From: Amanda Scholes on behalf of Planning.Responses
Sent: 23 April 2018 09:54
To: Planning Scanning
Subject: FW: Planning Application EP / 7 /18 / PL

From: Lol Pilfold [mailto:[LOL.PILFOLD@ARUN.GOV.UK](#)]
Sent: 19 April 2018 18:55
To: Anita Gardner; Malcolm Fitzgerald
Subject: Planning Application EP / 7 /18 / PL

Thank you for your reply to my email regarding the planning application EP/7/18/PL which I now understand has been granted an extension and will be decided by committee sometime in May of this year.

Elevations of new stircase to existing building

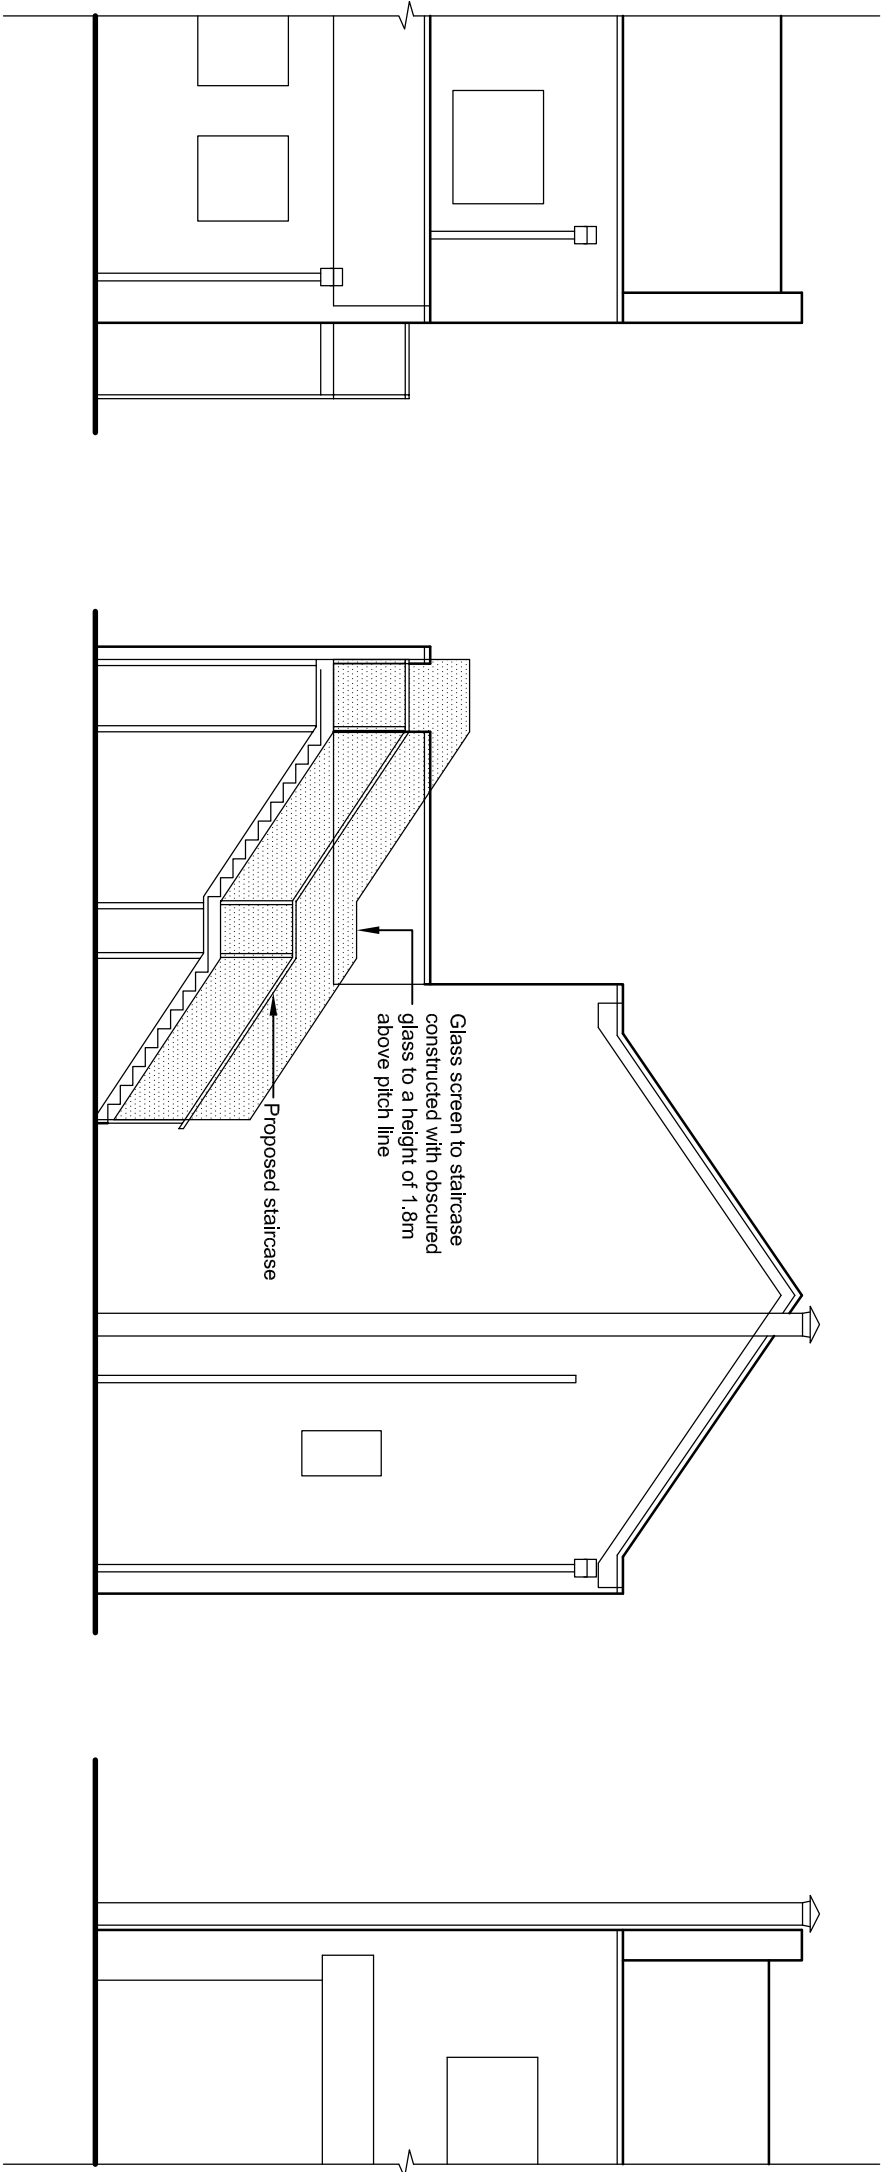
.. Firstly ,we have never considered the existing metal staircase used by Greenmanor's tenants to access their flats from their parked cars to be an "*impediment*"..

It forms the only access to the rear compound for tenants living over the shops from where they have been allowed by the landlord to park their vehicles regardless of their leases..***I agree that this also a legal issue but the tenants safety needs to be considered in planning matters and the relocation of the staircase effects this ..***

The only original internal staircase to the front parade is situated between flats 129 & 133 close to where the proposed fire escape is to be sited.

The distance for the young family in flat 143 to the new proposed fire escape is unaltered at 34 metres and the landlord's most recent tenants adjacent to them in flat number 139 have a little one and are expecting another child soon.

If there is a fire in either of the 2 Northern end flats over the shops, numbers 129 (over fish & chip shop) & 133, then there is no viable safe means of escape for the residents if the fire escape were to be relocated as per the plan.

In these circumstances people including young children would be directed towards the hazard via the various obstructions on the balcony, the question being and one has to ask it "is that acceptable given recent events?"

DRAWING TITLE
Proposed Site Plan, Block Plan
and Location Plan

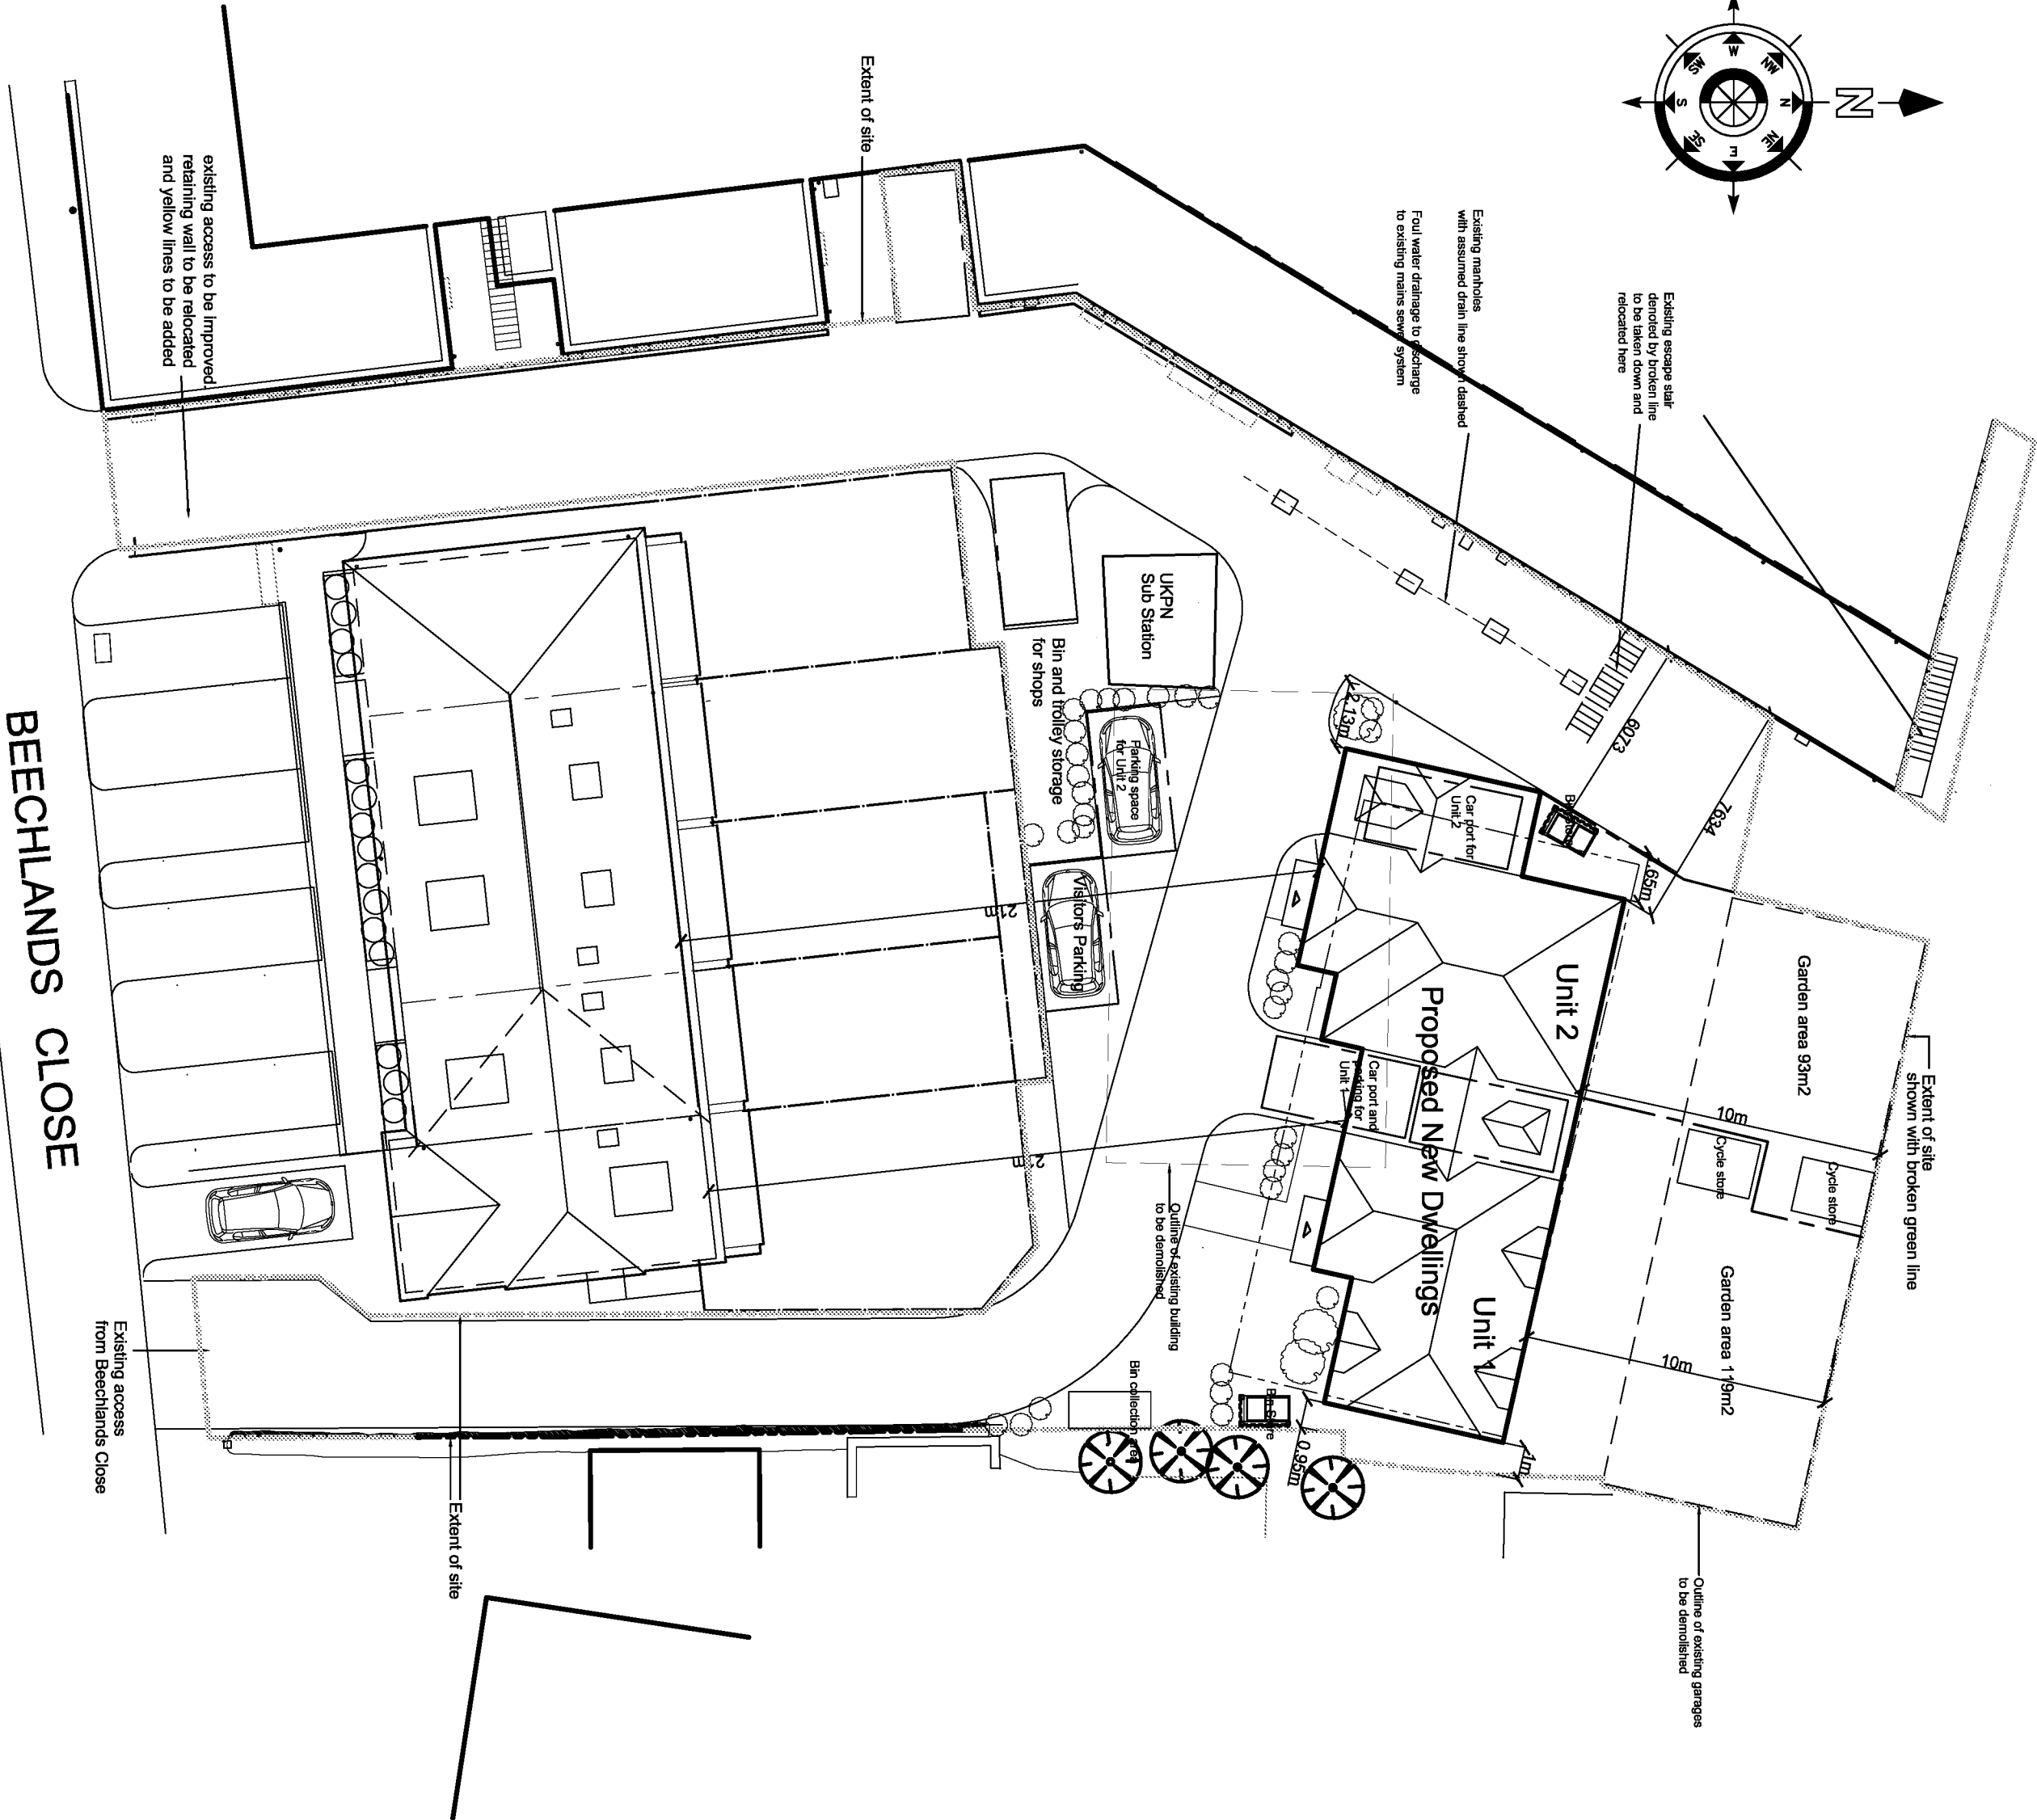
The "improved access" on the western side with yellow lines and ***"enforceable no parking"*** will further impact upon the tenants of the retail outlets who park there at present to load and unload, as they would have to utilise the parking at the front. This is supposed to be for customer parking and limited waiting time dependent, in addition it may not necessarily be available when required for loading and unloading .. ***again these vehicles should be included as being displaced ...***

Are the delivery vehicles/waste disposal vehicles using this new improved Western access route for the shops and flats able to access this narrow entrance ? ...and are they expected to reverse back out into Beechlands Close ?, clearly they will not be able to turn around and therefore, is that safe practice ?

Furthermore I would have thought that a door opening out onto this new vehicular non public route would have to be considered an obstruction/hazard to one party or another. This being especially so as the pedestrian access would be under a ***"not uncommon shared surface arrangement"*** and ***"no pedestrian zones would be***

required". Even the sensible inclusion of a pavement would not prevent a hazard to those walking past these doors. This would also further restrict the width of the route for vehicles having to use it.
